**RE: ERECTION OF HOUSE AND GARAGE 15 FLEET ROAD, HOLBEACH
for TUDOR HOMES**

Further to your telephone call to this office please find enclosed revised plans
showing rear dormers removed as requested.

Amendment: Rear dormers removed
Dwg nos. 2749-1A & 2749-2A

Peter Humphrey Associates ARCHITECTURAL DESIGN AND BUILDING		
PROJECT PROPOSED HOUSE 15 FLEET ROAD HOLBEACH		
CLIENT TUDOR HOMES	SCALE 1:100	JOB No. 2749 - 2A
DATE AUG 2002	DATE REVISED 2-10-02 A	DETAILS Rear dormers removed

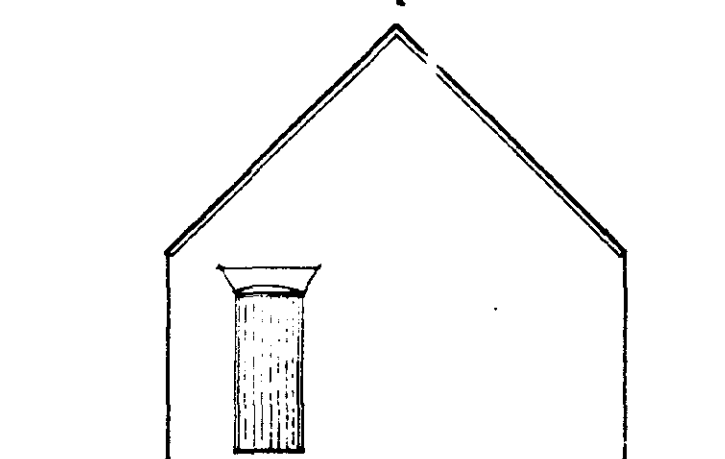
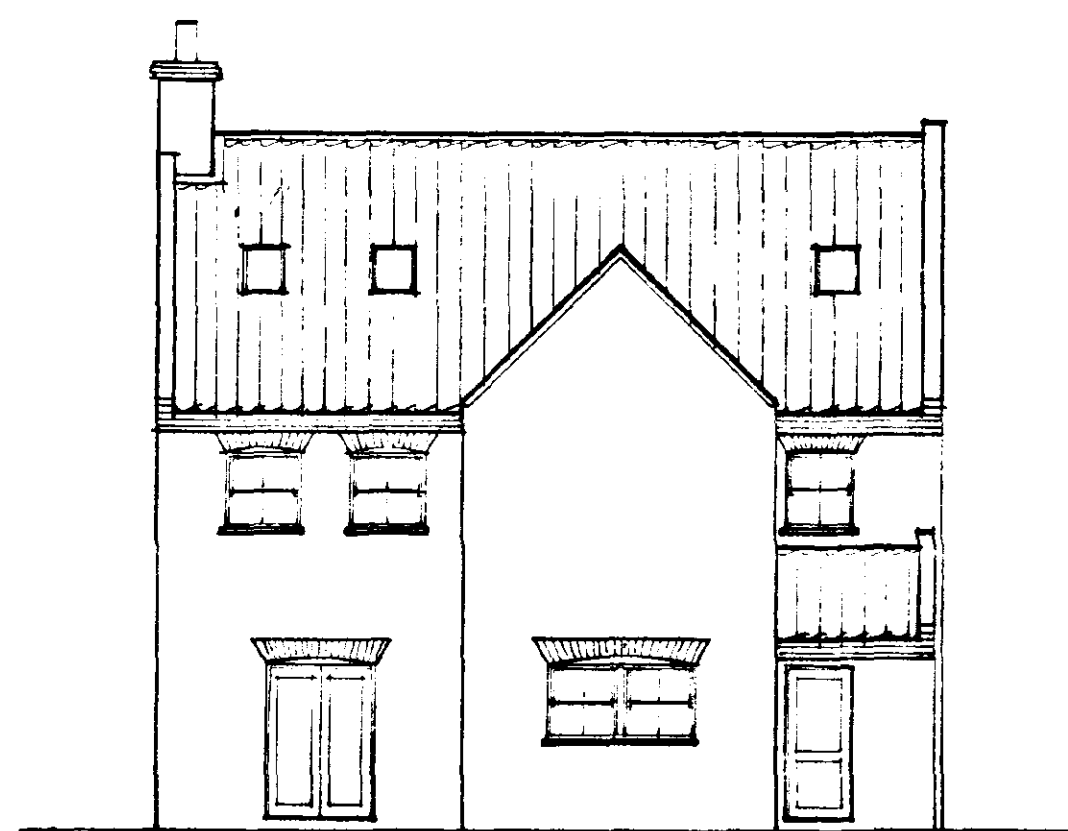
(Give a full detailed list of the changes, and
also mark these clearly on the accompanying plans.
Only the changes listed here will be considered.)Rear Dormers
Removed
